Application for a non-material amendment following a grant of planning permission.

Alterations to entrance including new doors window and canopy, erection of a single storey rear extension, path, additional car parking spaces and internal remodeling works to allow the change of use from library storage depot and office to a Register Office for the registration of births, deaths and still-births, dealing with legal preliminaries for ceremonies; conducting ceremonies and associated functions.

Reference number:	<input type="text" value="CCC/20/020/FMW"/>
-------------------	---

Scale 1 : 50	@A1	Date 01/09/20	Drawn KJR
Drawing Title Existing Ground Floor Plan - Sheet 1 of 2	Checked SD	Revision P4	
Drawing Number J4523-YMD-01-GF-DR-A-2011

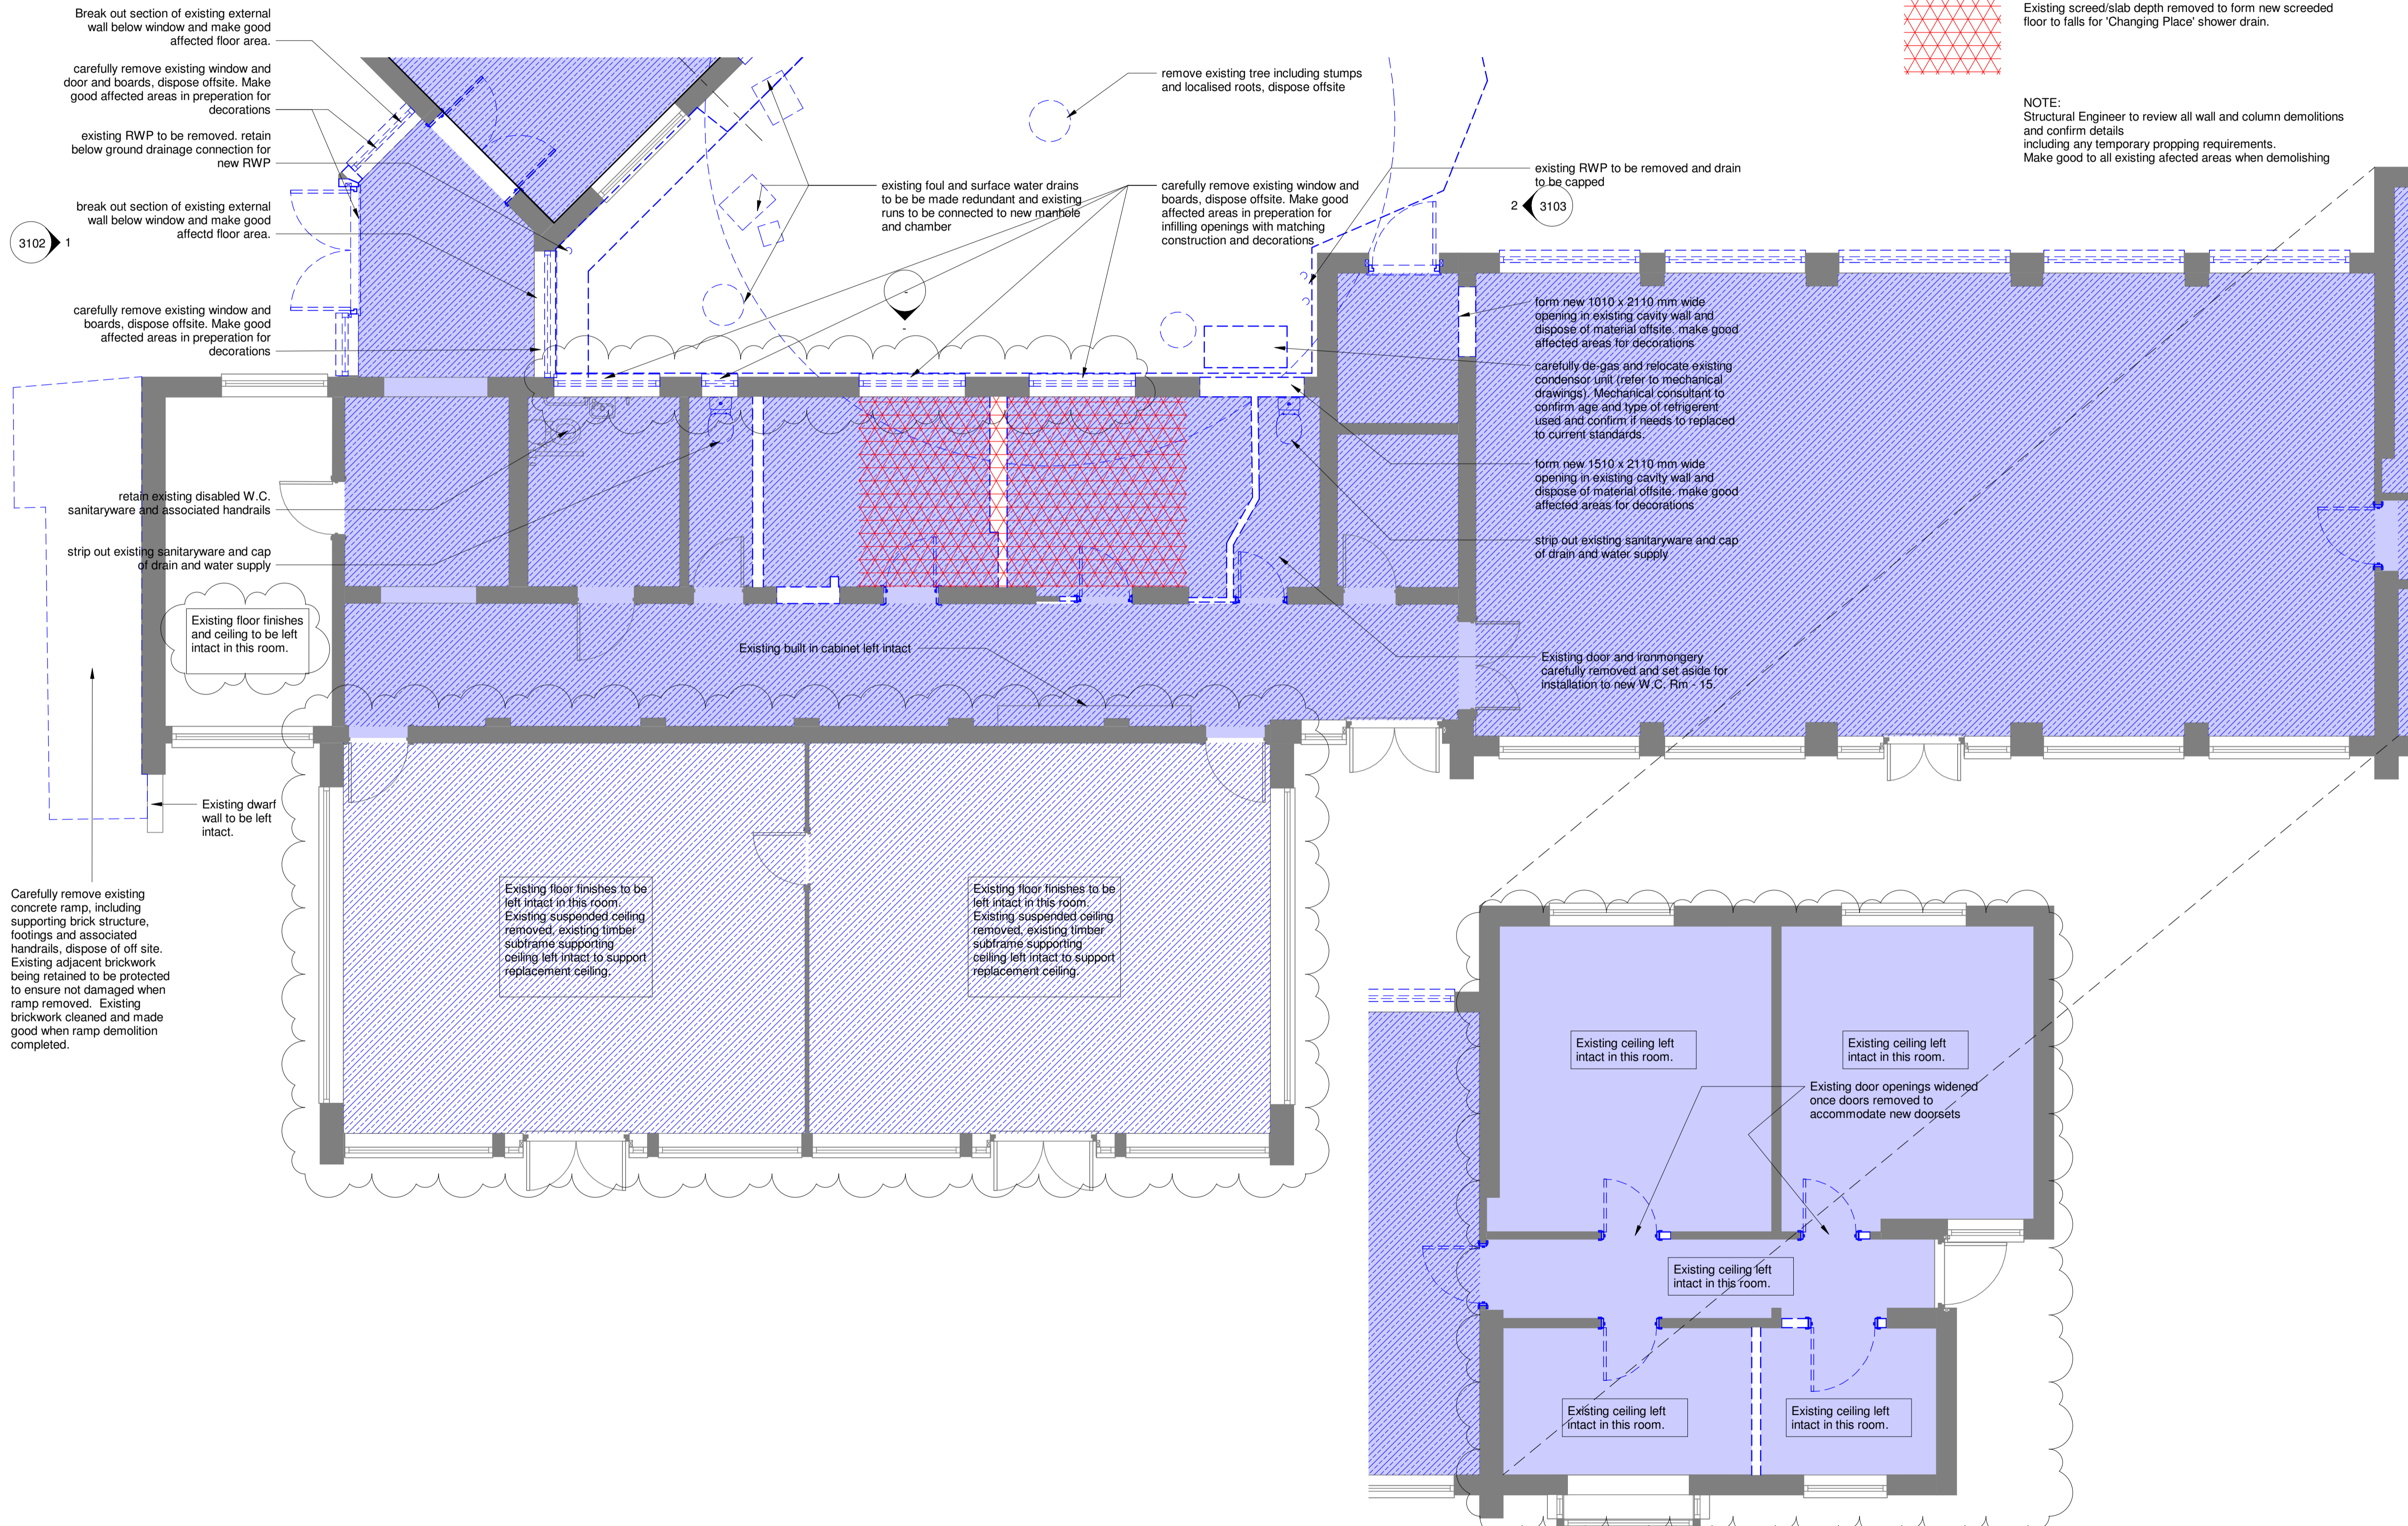
5. Windows; Secure Store Room/Safe Room 28 windows left intact, windows to be secured with internal railings not shutters. Plant Room 4 external doors updated and external wall infill proposal changed to with existing structure. New windows/doors proposed to Entrance Lobby and Reception/Waiting 2. New high level metal framed windows proposed to be installed to Interview 1, Interview 2 & Interview 3. All other existing windows to be retained and secondary glazing installed. Windows to toilets 13, 14, 15 & 16 which are internalised by new rear extension removed and openings infilled to provide adequate acoustic privacy to toilets.

5. Windows; Secure internal railings proposed in lieu of shutters in safe room to provide free flow of air and avoid potential for condensation with potential to damage windows. Existing windows replaced or to have secondary glazing to improve thermal performance of building.

Scale	Date	Drawn
As indicated @A1	01.03.2021	SD
Drawing Title		Checked
GA Ground Floor Plan- Sheet 2 of 2		DY
Drawing Number		Revision
J4523-YMD-01-GF-DR-A-2202		P4

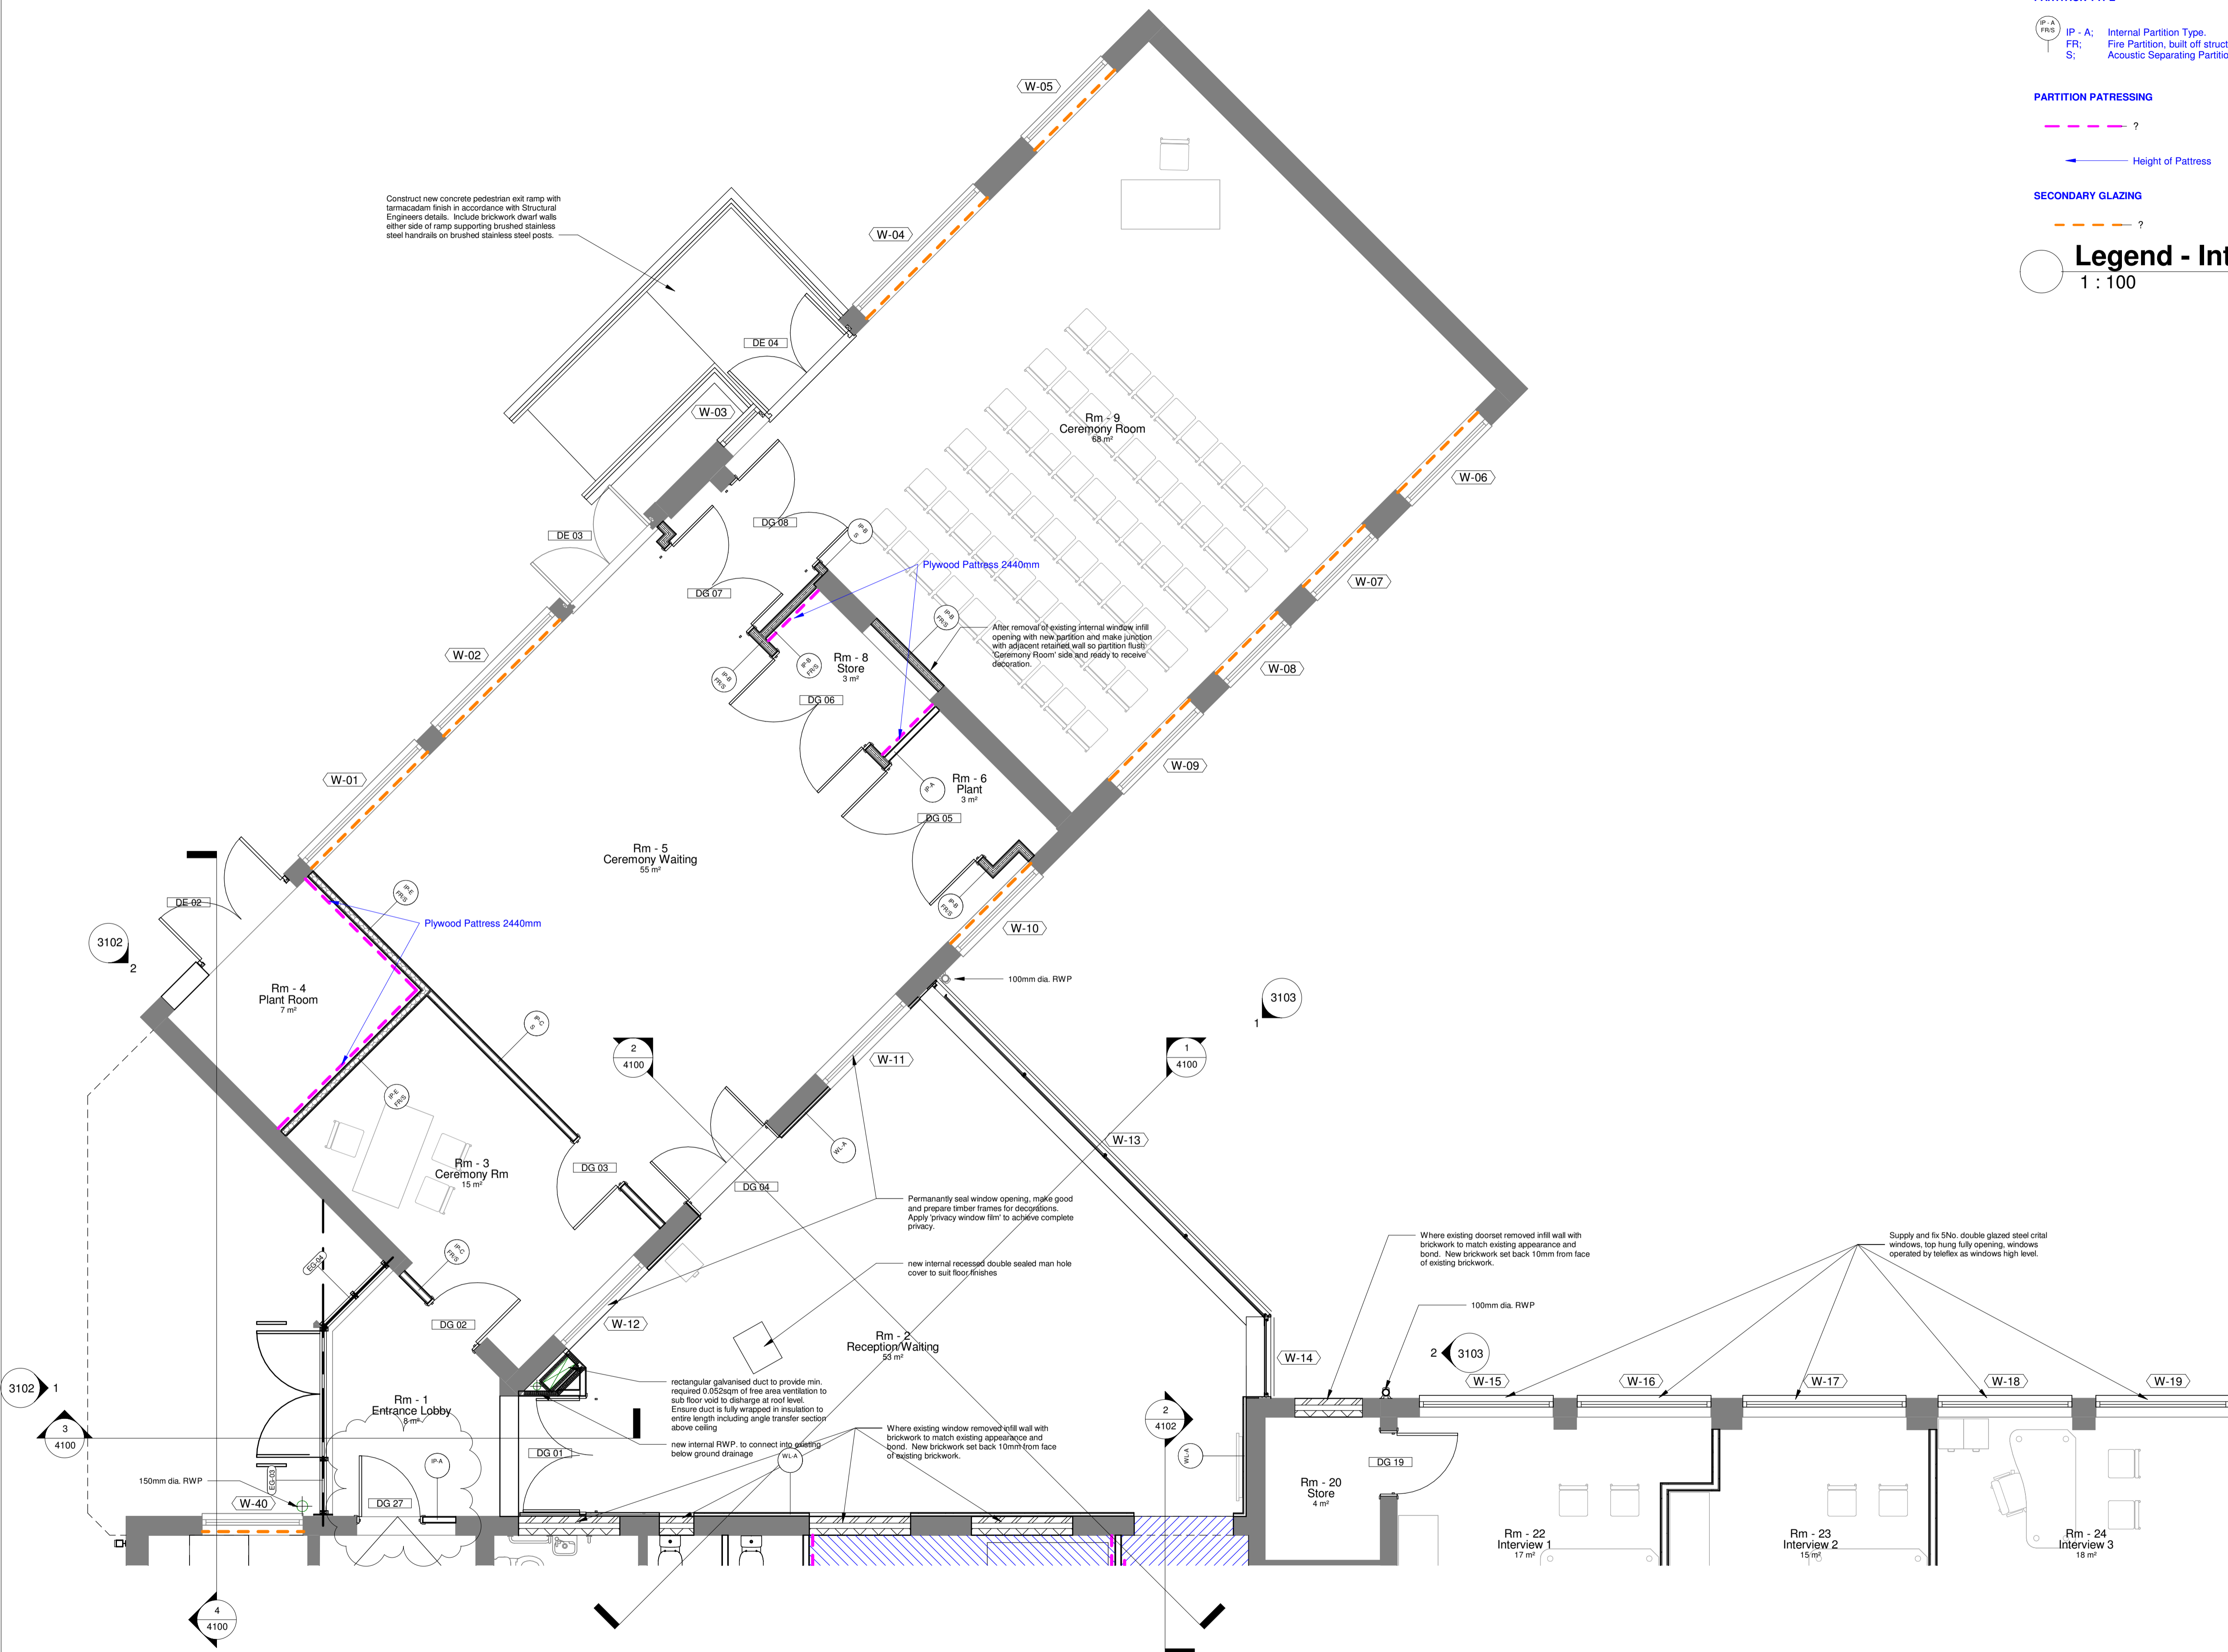
1. Photographic Area; Paving clarified. Proposed Pagoda changed to a timber Pergola. External plant area revised to accommodate required plant.
2. External exit from ceremony room; Rationalised to ensure proposals work with existing structure. Ramped egress with handrail proposed to provide level access from ceremony room.

3. Proposed covered cycle shelter relocated; To improve vehicle access in car park.
4. Cycle parking uncovered; existing proposed to be left intact for re-use, no additional cycle parking now proposed.

1. Photographic Area; To provide functioning space for required outdoor plant. Pergola more practical and in keeping with area than Pergoda.
2. External exit from ceremony room; To provide DDA compliant egress. External door arrangement revised to ensure existing elevation structure not undermined.

3. Proposed covered cycle shelter relocated; To improve vehicle access in car park.
4. Cycle parking uncovered; Change proposed to maximise space available for vehicle movement and make use of existing bike hoops.
